PRE-APPLICATION REVIEW TEAM (PRT) MEETING NOTES

PA# 18-349 Date: 12-11-2018 Time: 1:30pm

Address: 10000 Central Ave. NW

REQUEST: 641 Station, Car Wash, Drive through, Restaurant, Auto Parts Store

SITE PLAN

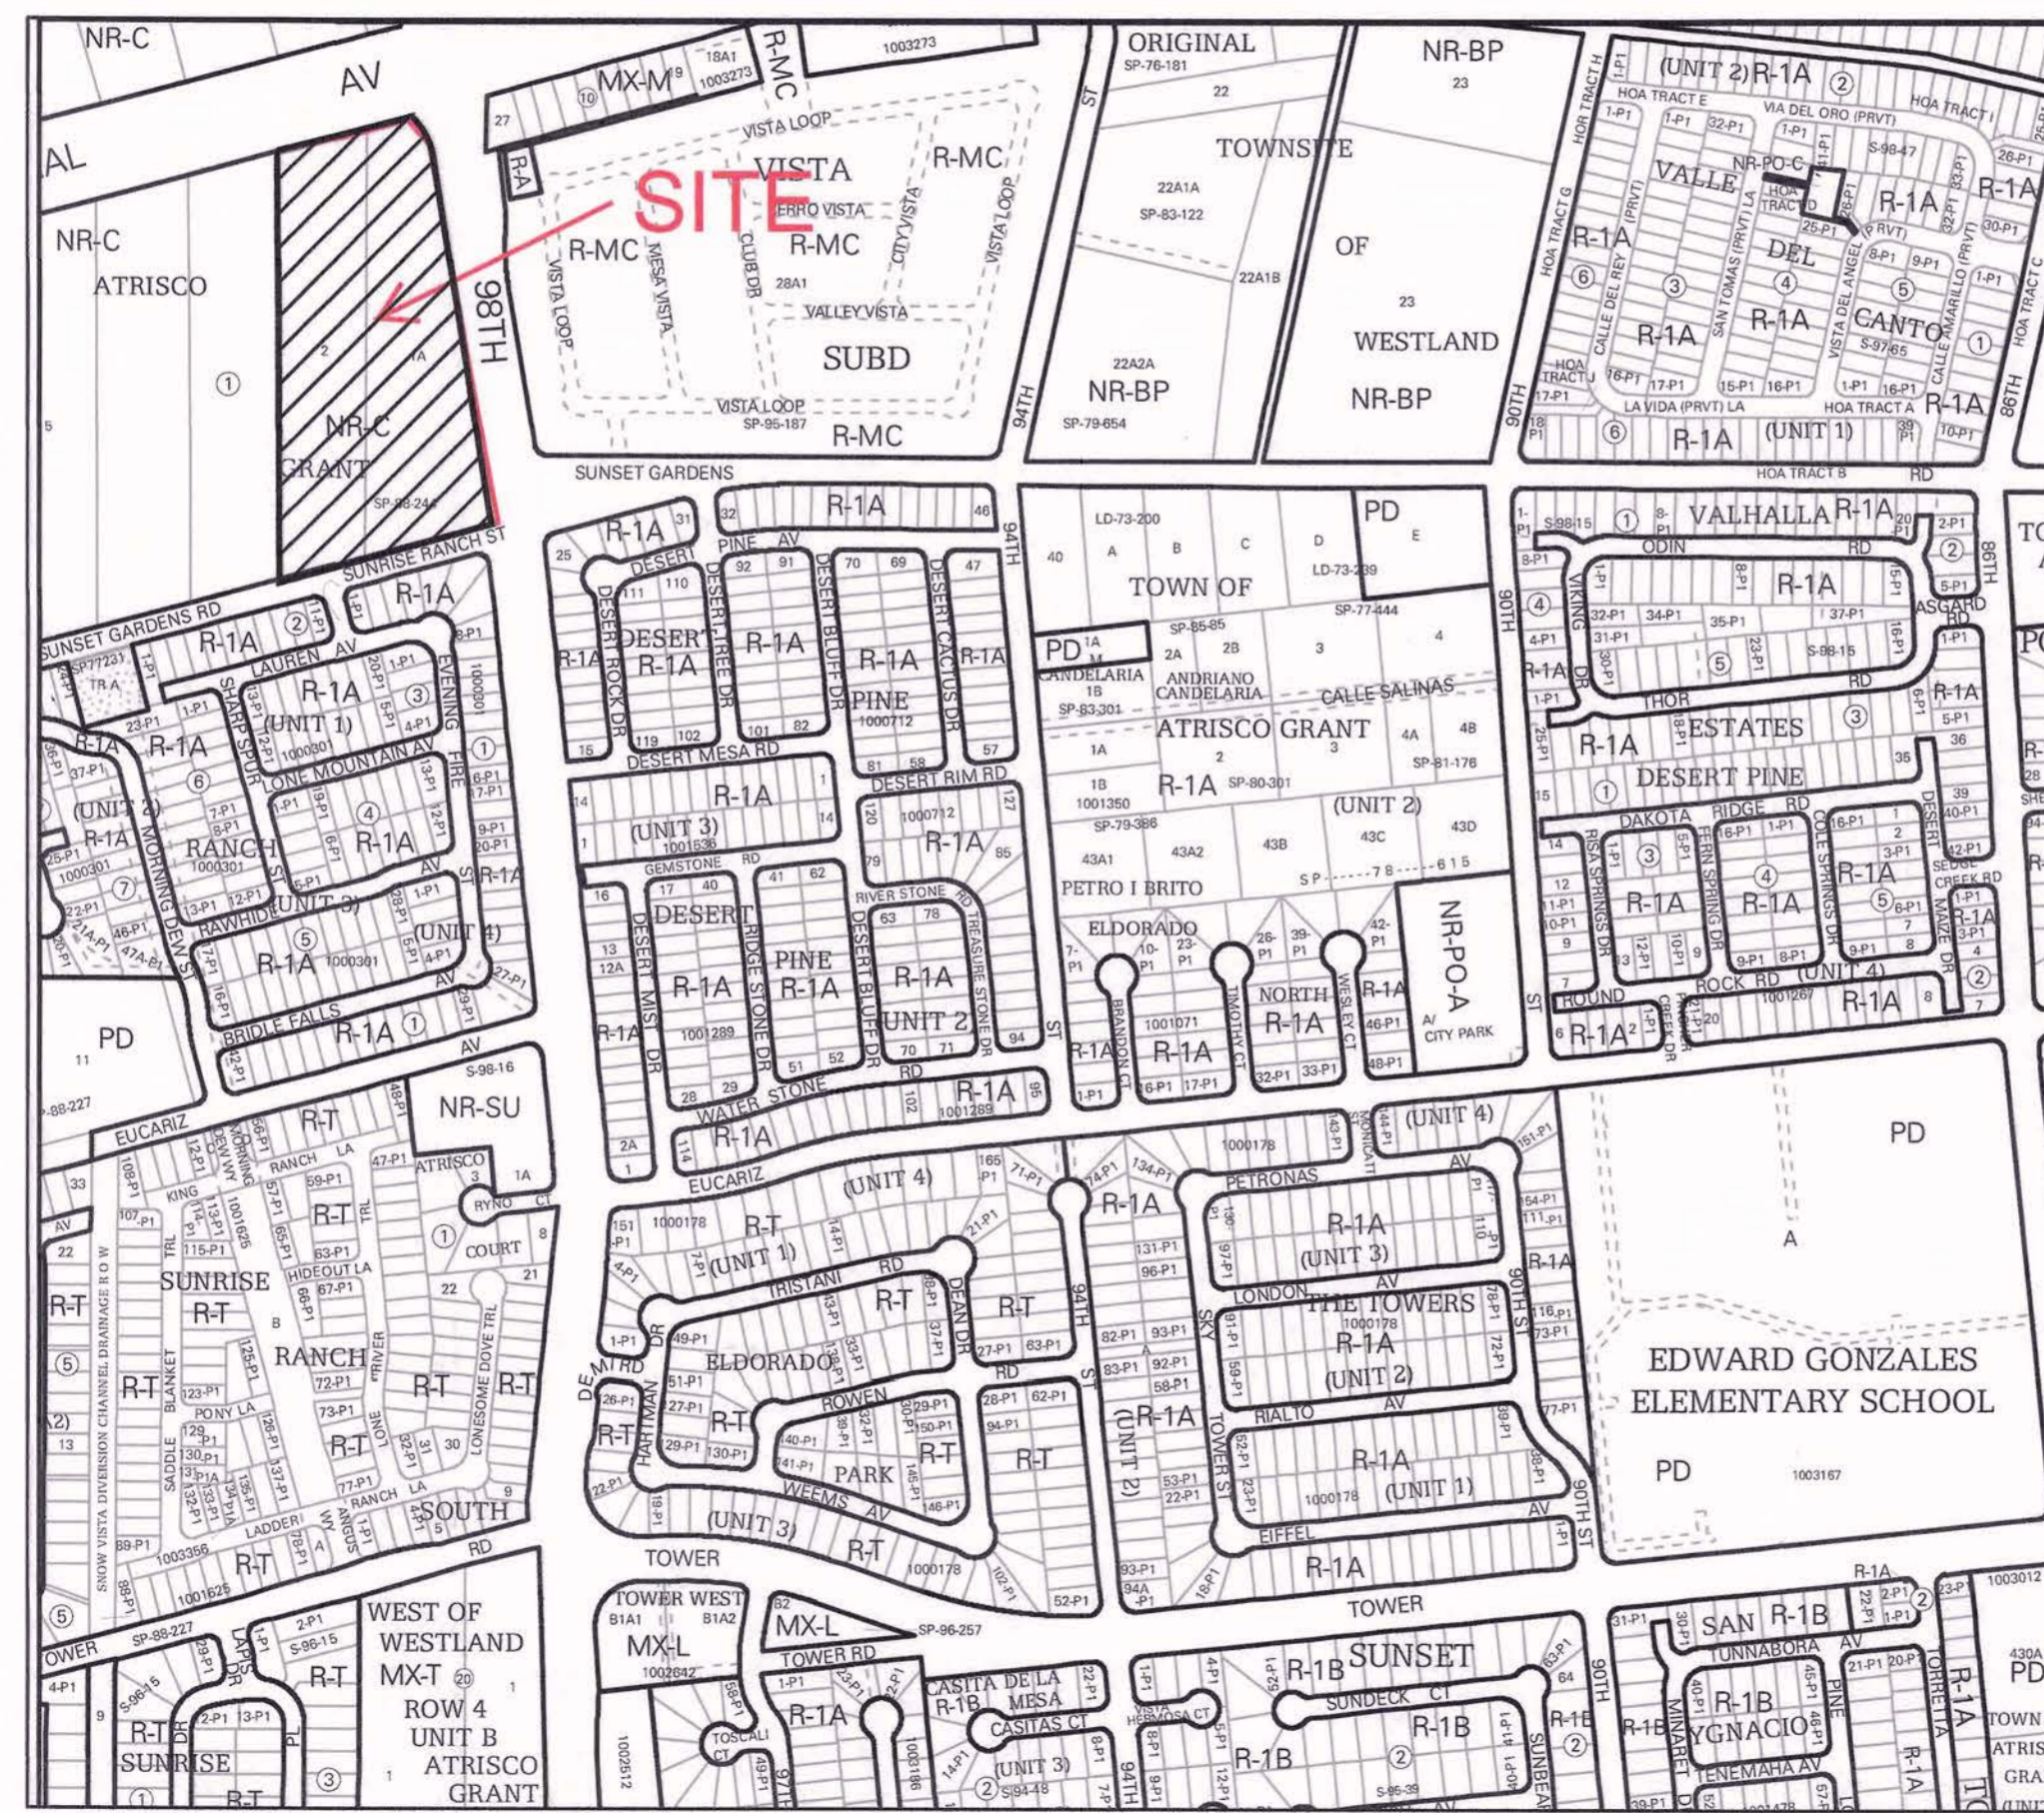
Transportation - 2 entrances shown not allowed; TIS required

drive 200' from ^{north} corner

150' fm south corner
